**Application Reference:** 6/2023/2388/COND

**Proposed development at:** YMCA 90 Peartree Lane Welwyn Garden City AL7 3UL

**Proposal:** Submission of details pursuant to conditions 11 and 39 (Samples of Materials), 13 and 41 (Landscape Plan and Details) on planning permission 6/2019/2714/OUTLINE

PLANT SCHEDULE

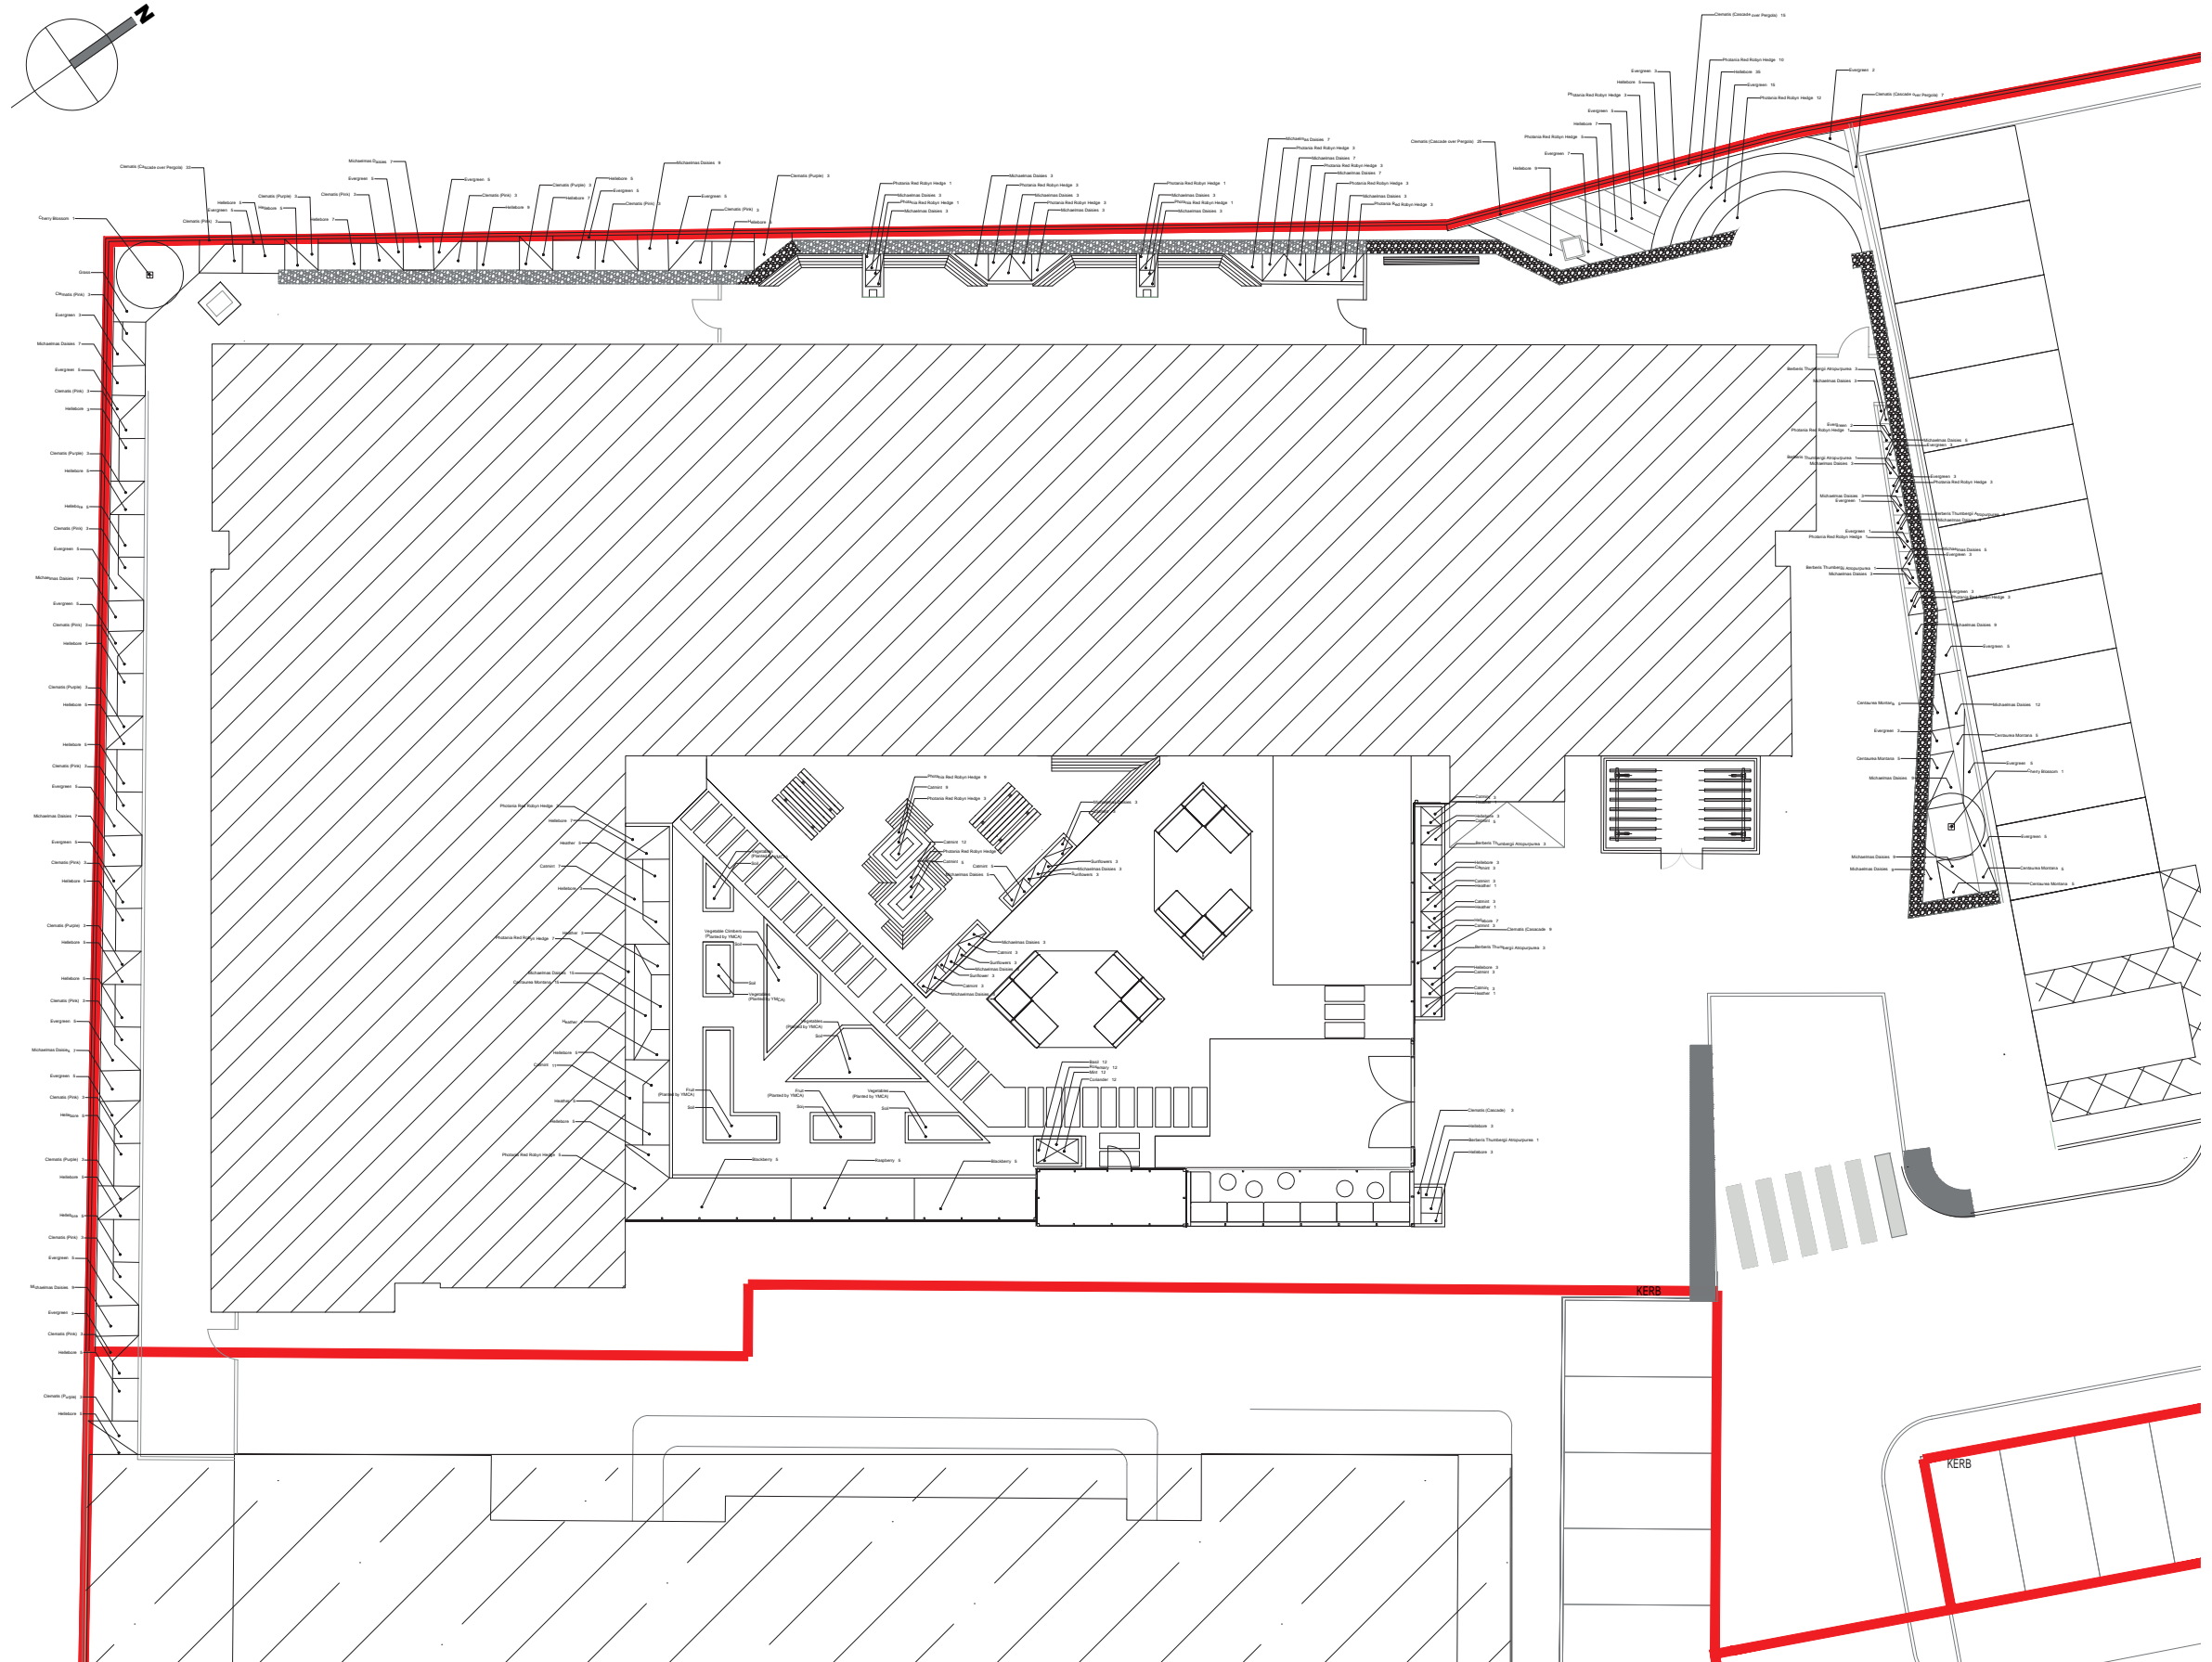
Having regard to the above, insufficient information has been submitted to discharge conditions 13 and 41. The reasons for this include that insufficient information has been provided in relation to; the size of plants which are to be planted; the method and aftercare of the proposed planting; and; the type and specification of the proposed Green Roof. As a result, the information submitted does not meet the requirements of these conditions and a new application(s) which seeks to address these deficiencies will need to be submitted to the Council for determination.
